OFFICIAL NOTICE OF DECISION

CITY OF ALBUQUERQUE
PLANNING DEPARTMENT
DEVELOPMENT REVIEW BOARD

- 2. Project # 1002602**
03DRB-00642 Major-Vacation of Public Easements
03DRB-00643 Minor-Prelim&Final Plat Approval

MARK GOODWIN & ASSOC agent(s) for SUNSET WEST request(s) the above action(s) for all or a portion of Block(s) 2, Tract(s) A, **EAGLE ROCK ESTATES UNIT II, POND RECLAMATION**, zoned R-D/7DU/ac, located on LOUISIANA BLVD NE, between EAGLE ROCK AVE NE and OAKLAND AVE NE containing approximately 8 acre(s). [REF: DRB-97-374] (C-19)

EAGLE ROCK ESTATES - UNIT II
 POND RECLAMATION
 GRADING AND DRAINAGE PLAN

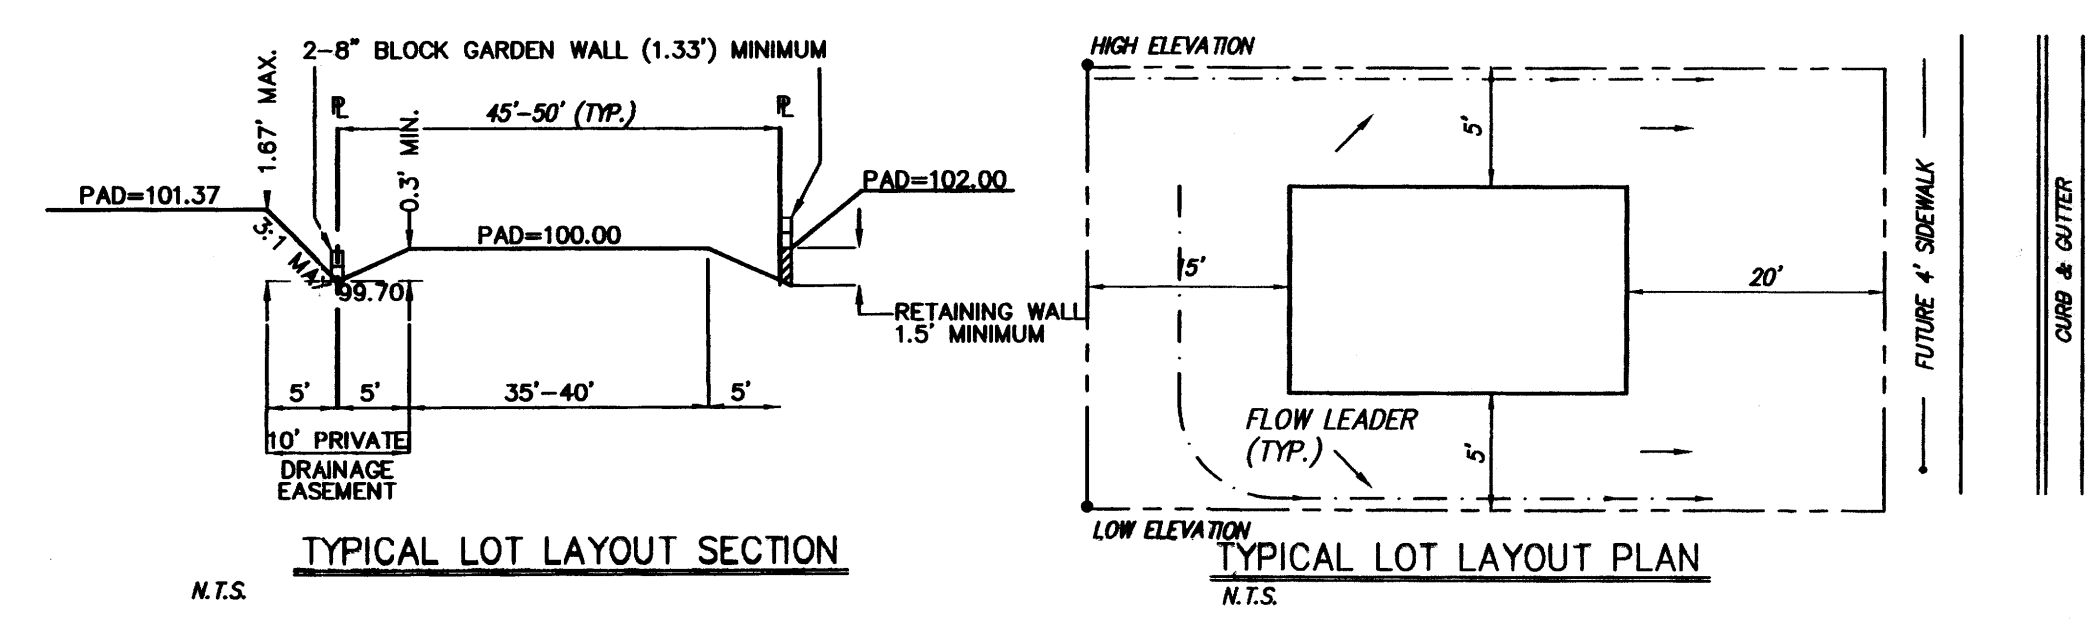
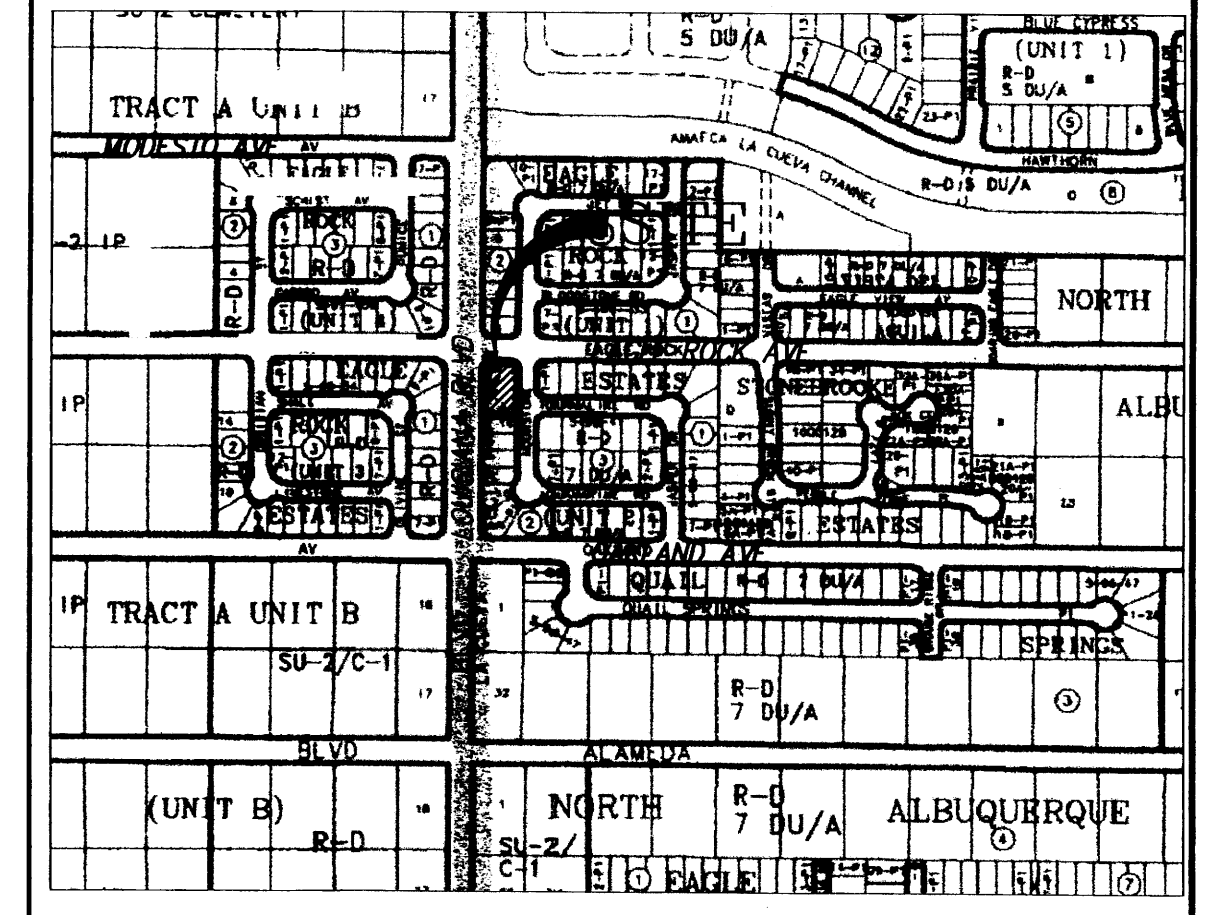
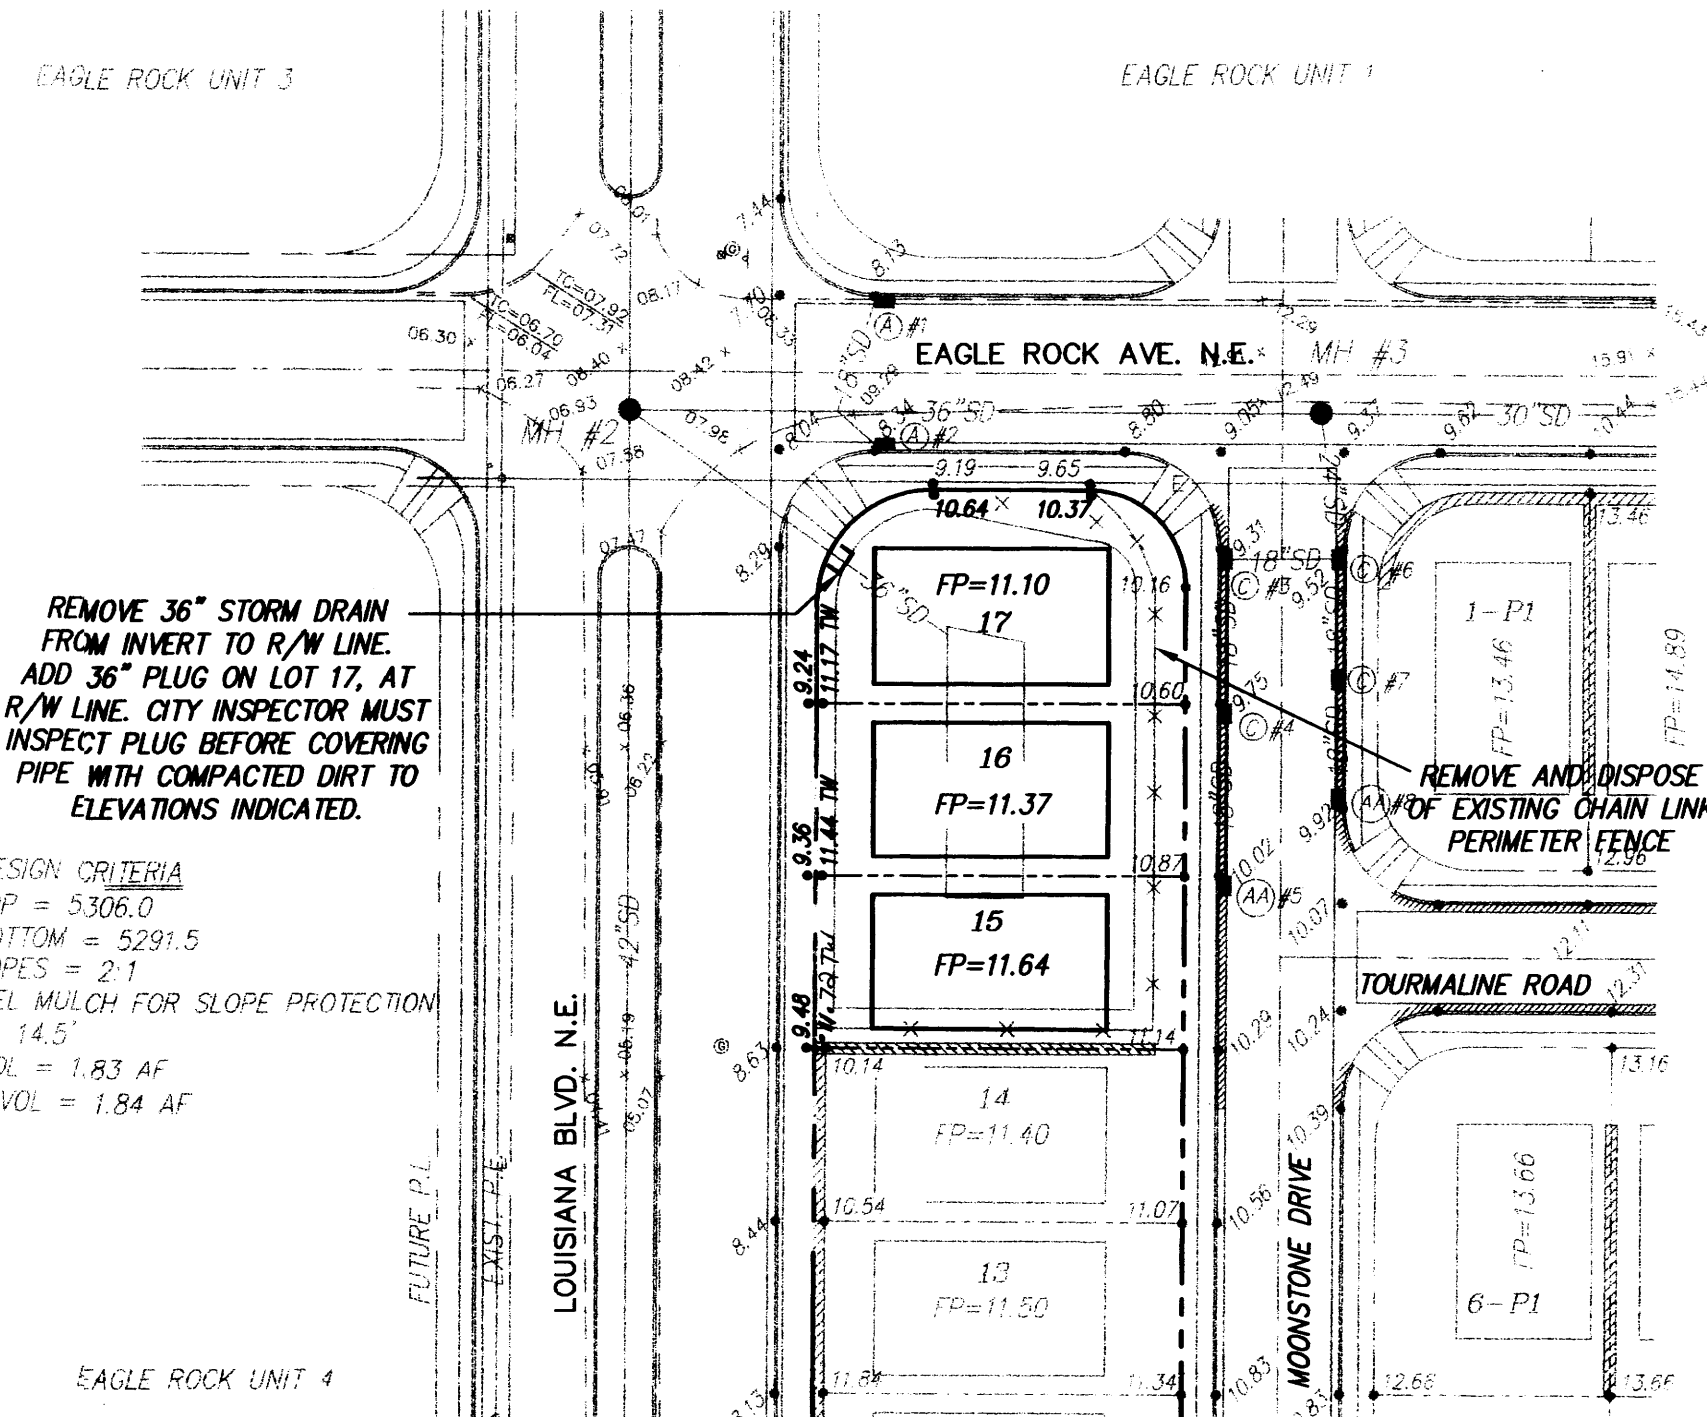
With the approval of the grading plan engineer stamp dated 4/22/03 the preliminary plat was approved with final sign off delegated to City Engineer for engineer certification of grading plan and 15-day appeal period and to Parks for Open Space note, park dedication and the DXF file.

1. To subdivide Tract "A", Block 2 into 3 residential lots.
2. Vacate temporary Public Drainage Easement as shown hereon.

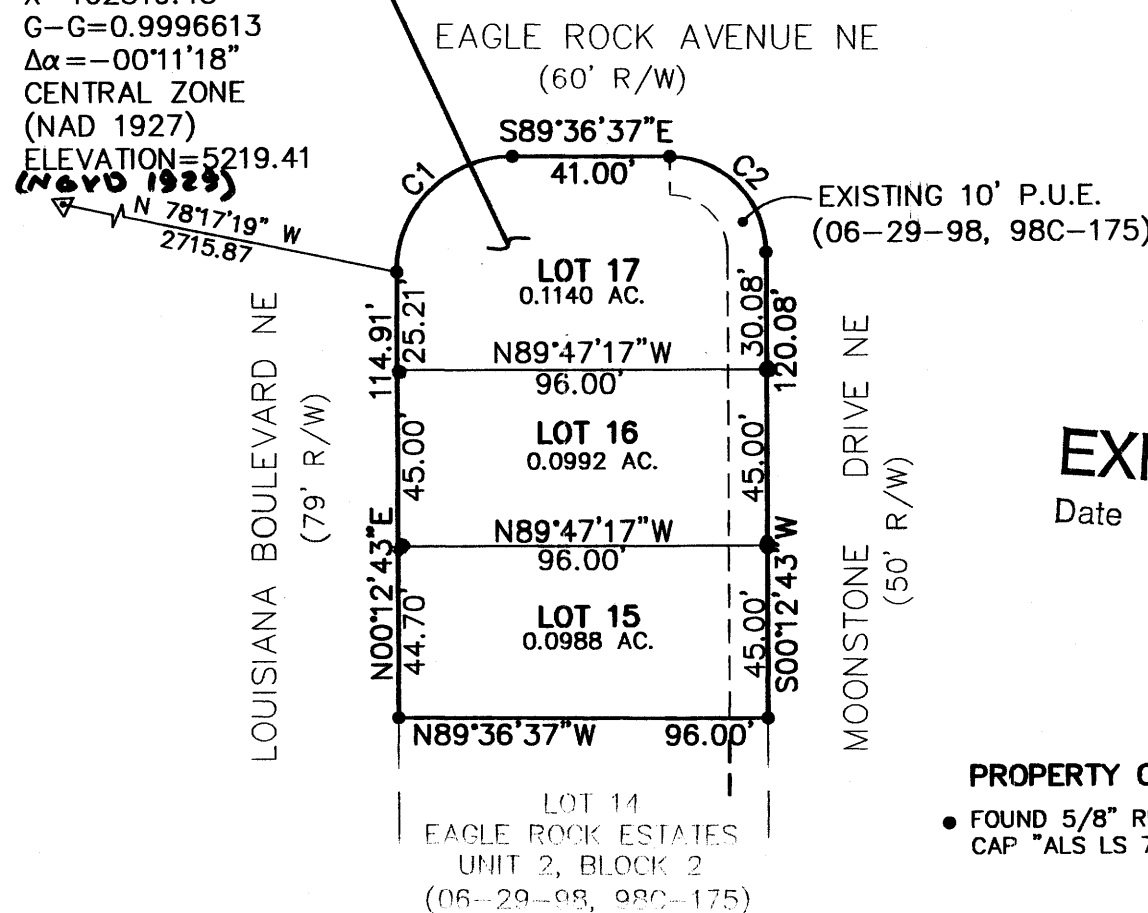
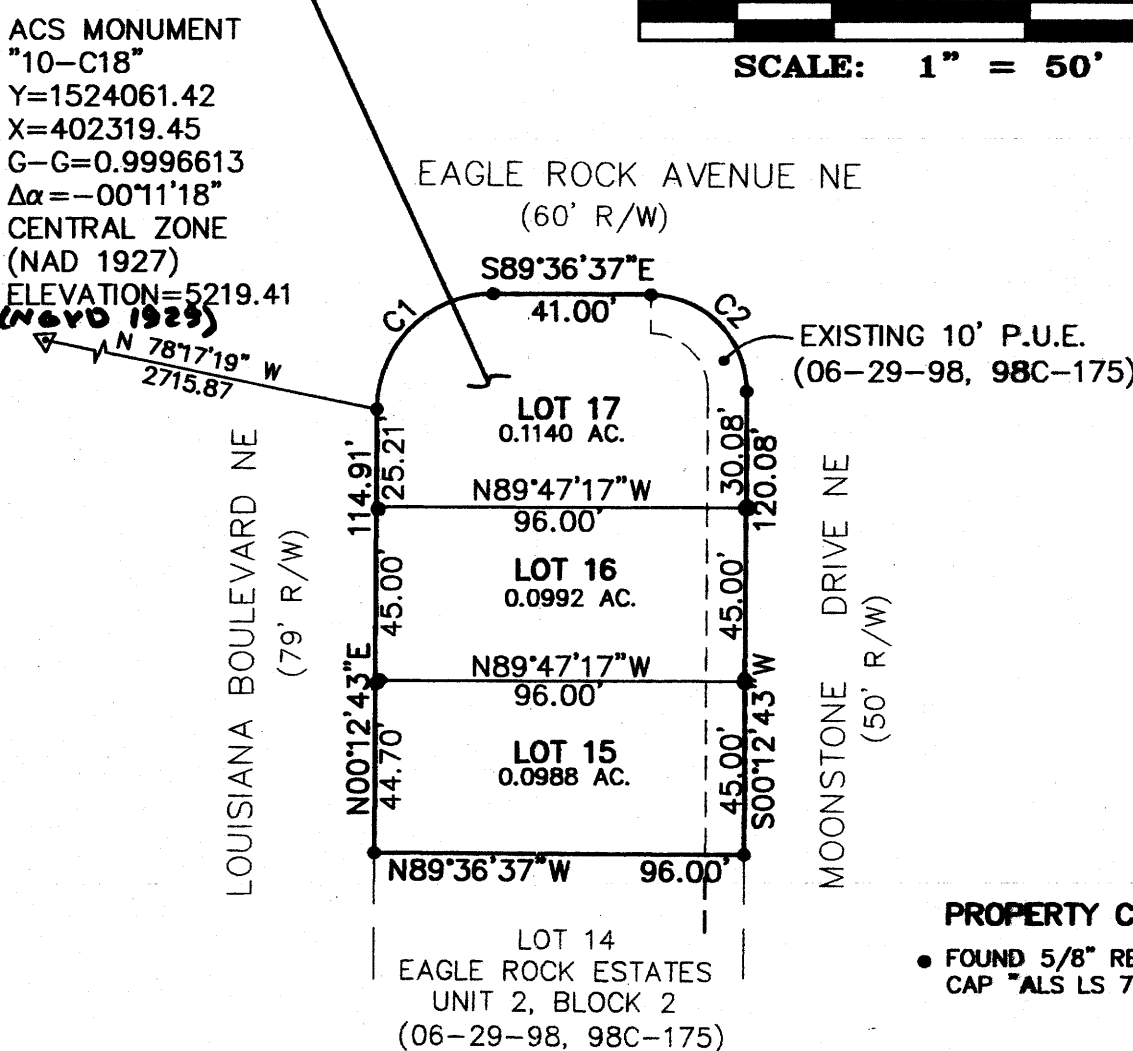
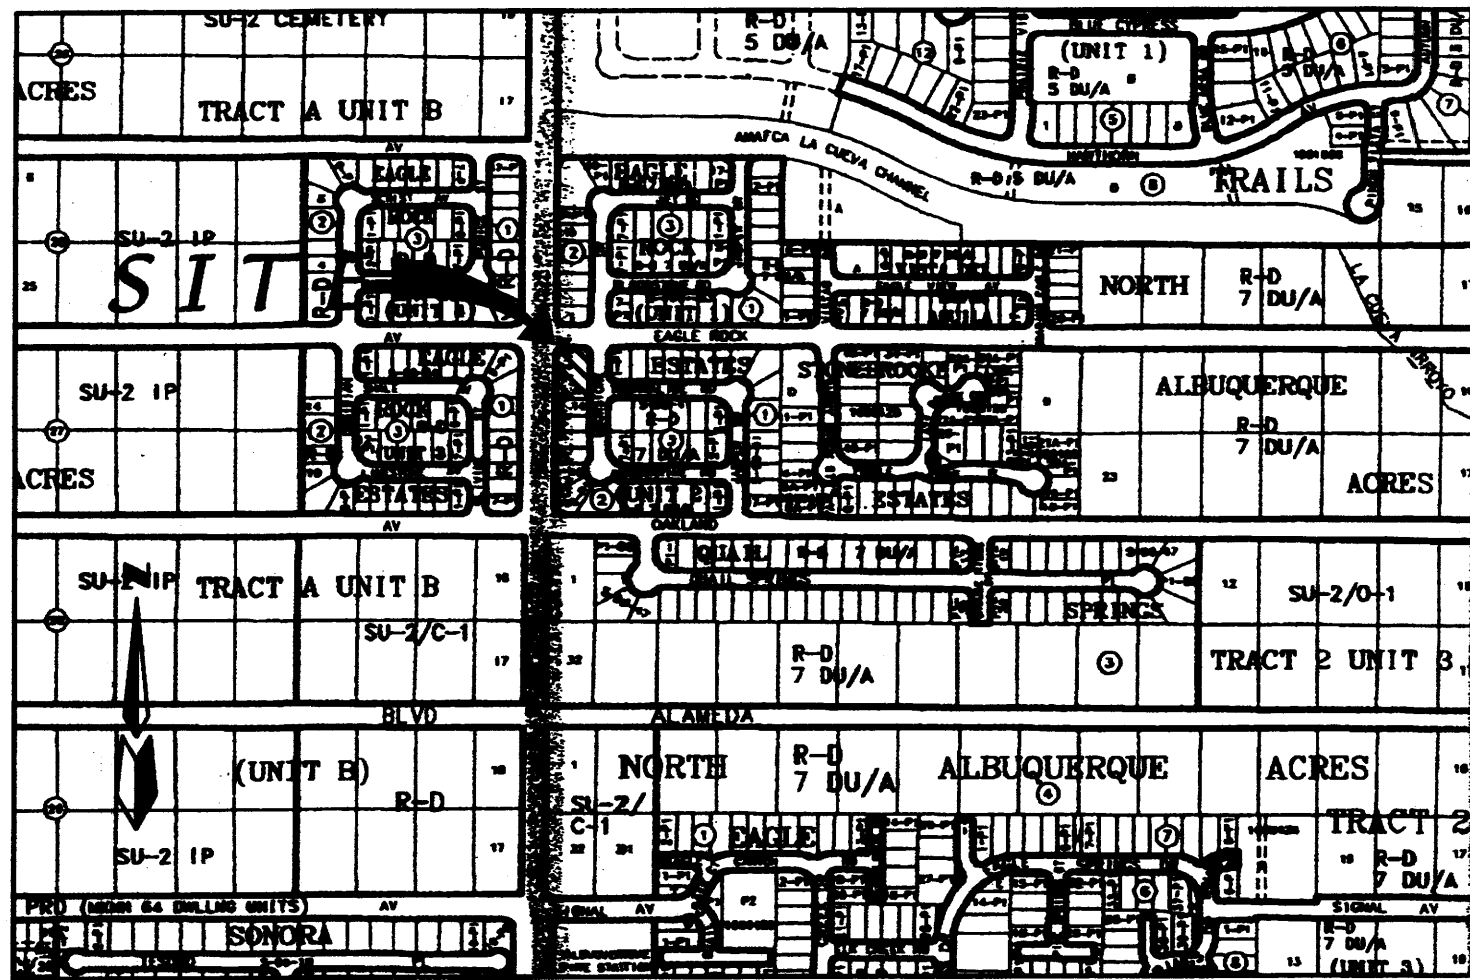
At the May 21, 2003, Development Review Board meeting, the Vacation was approved as shown on Exhibit B in the Planning file, subject to the following Findings and Conditions of the Subdivision Ordinance:

1. Final disposition shall be through the City Real Estate Office.
2. The vacated property shall be shown on a replat approved by the Development Review Board and the approved replat shall be filed for record with the Bernalillo County Clerk's Office within one year.
3. Affected utility companies shall acknowledge the vacation by their signatures on the replat.
